Your ref: 3/2021/0578

Date: 25th June 2021

Planning application 3/2021/0578: Discharge of Condition 10 (Specifications of replacement windows) and Part Discharge of Condition 6 (Recording of First Floor) of Listed Building Consent 3/2020/0763.
20-22 Talbot Street, Chipping PR3 2QE

PHOTOGRAPHIC RECORD OF FIRST FLOOR STRUCTURE: PHASE 1 REPORT

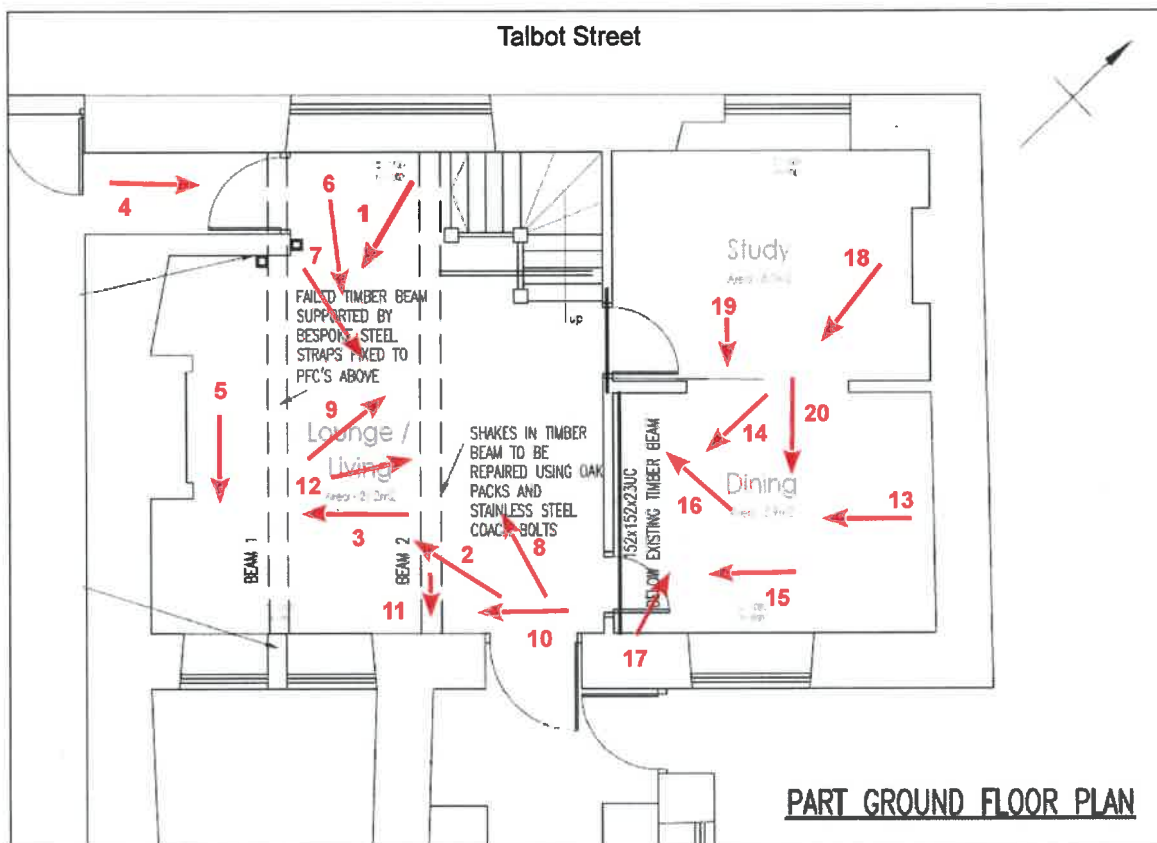
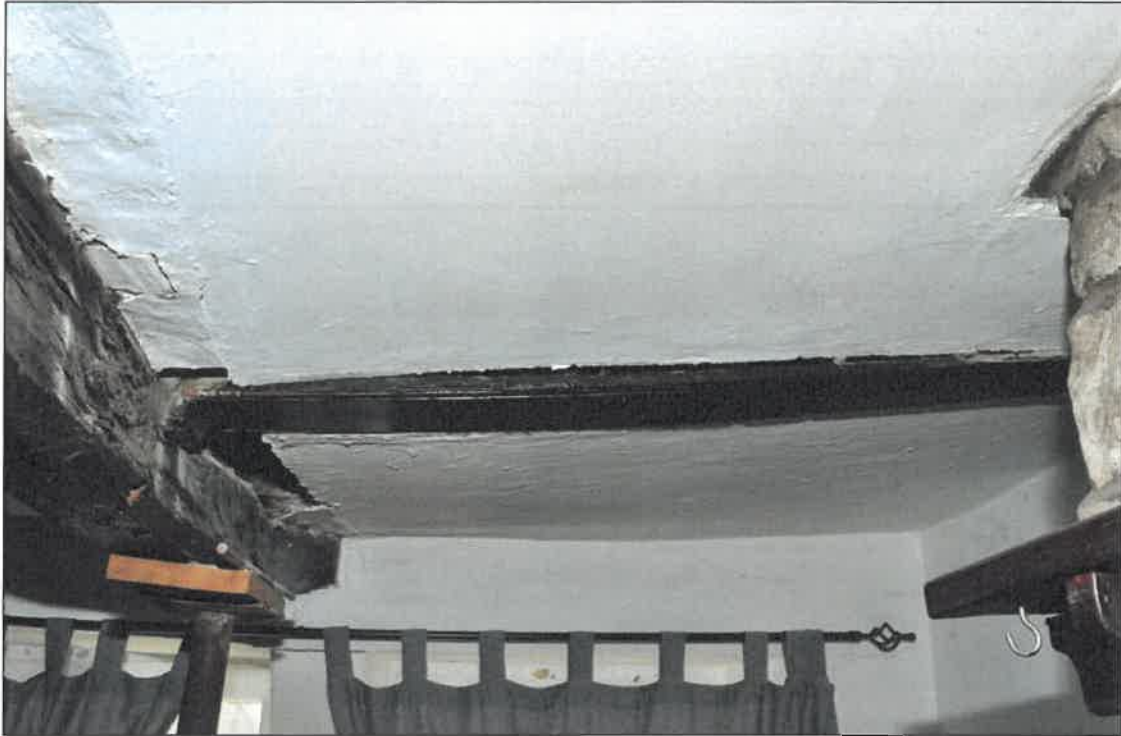
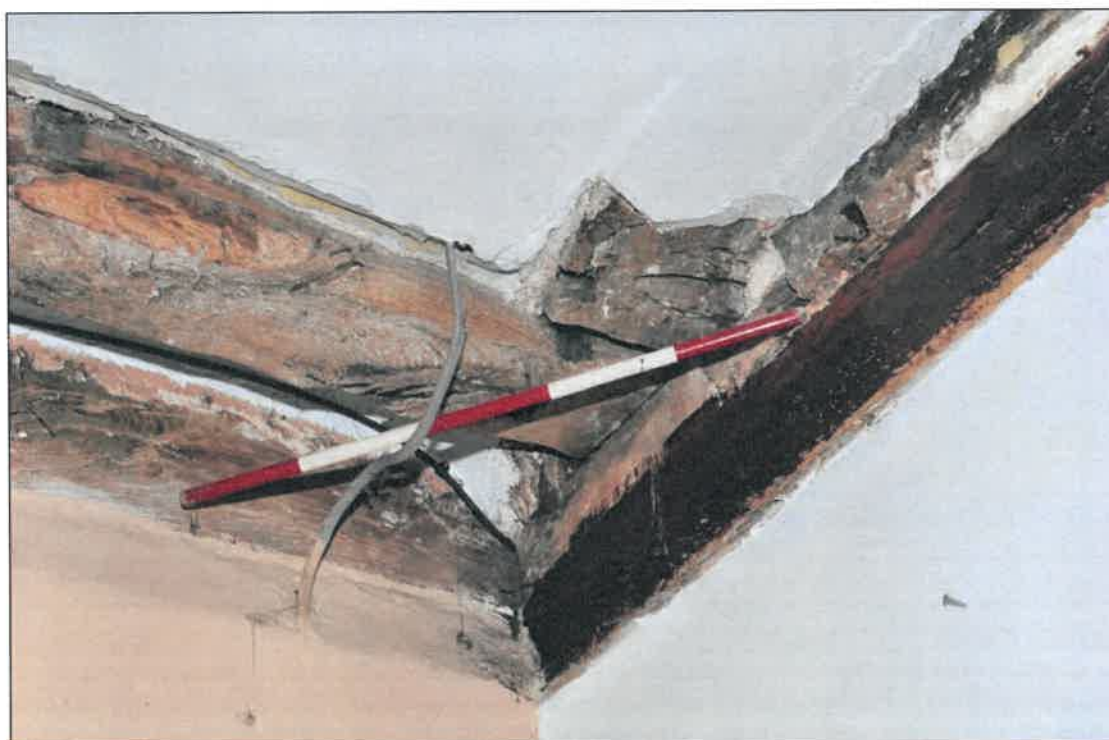
Thank you for your consultation on the above application. The supplied record of the first-floor beams 'as existing' appear appropriate and adequate. It is noted that a full timetable for the works has not been supplied (section 4), but the intention to return and document the features during the works is noted.

It is recommended that the resent report be approved, but that the condition not be discharged until the further recording has been undertaken and a revised report received.
